April 27, 2021

**Re: Chase Bank - Eubank**  
**340 Eubank Blvd NE, 87123**  
**30-Day Temporary Certificate of Occupancy**  
**Transportation Development Final Inspection**  
Engineer's/Architect's Stamp dated 9-2-20 (K21D009C)  
Certification dated 4-26-21

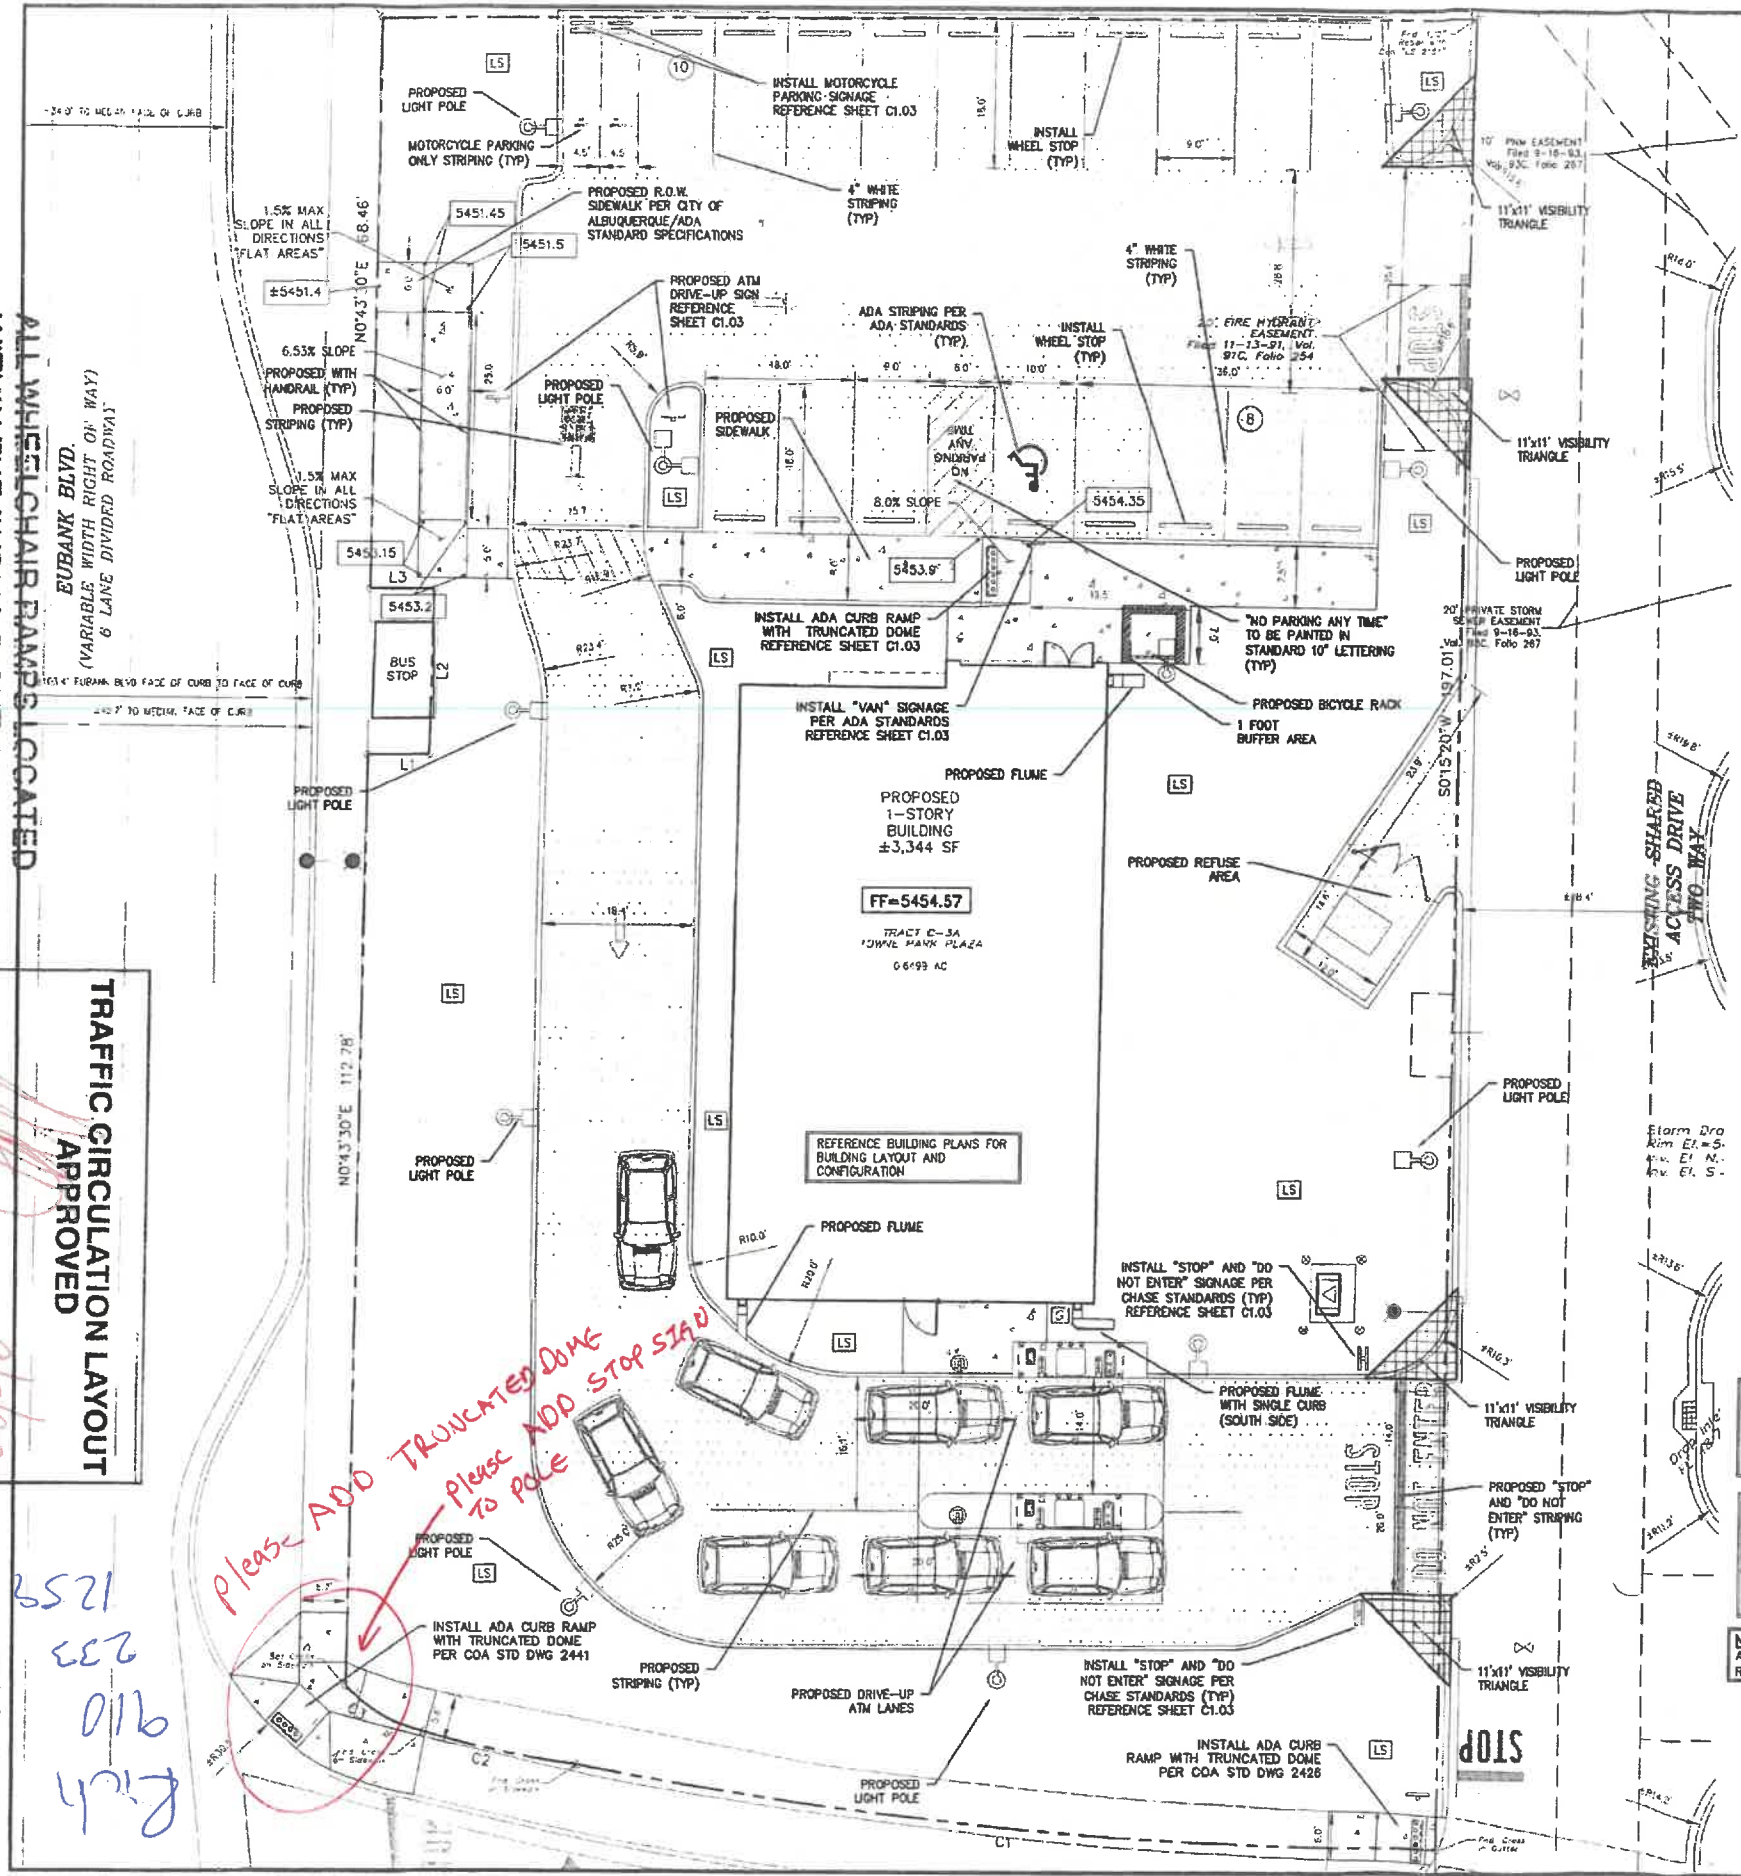
- Please add Truncated Dome and Stop Sign. See attached plan for location.
- Please remove construction debris and equipment from site.
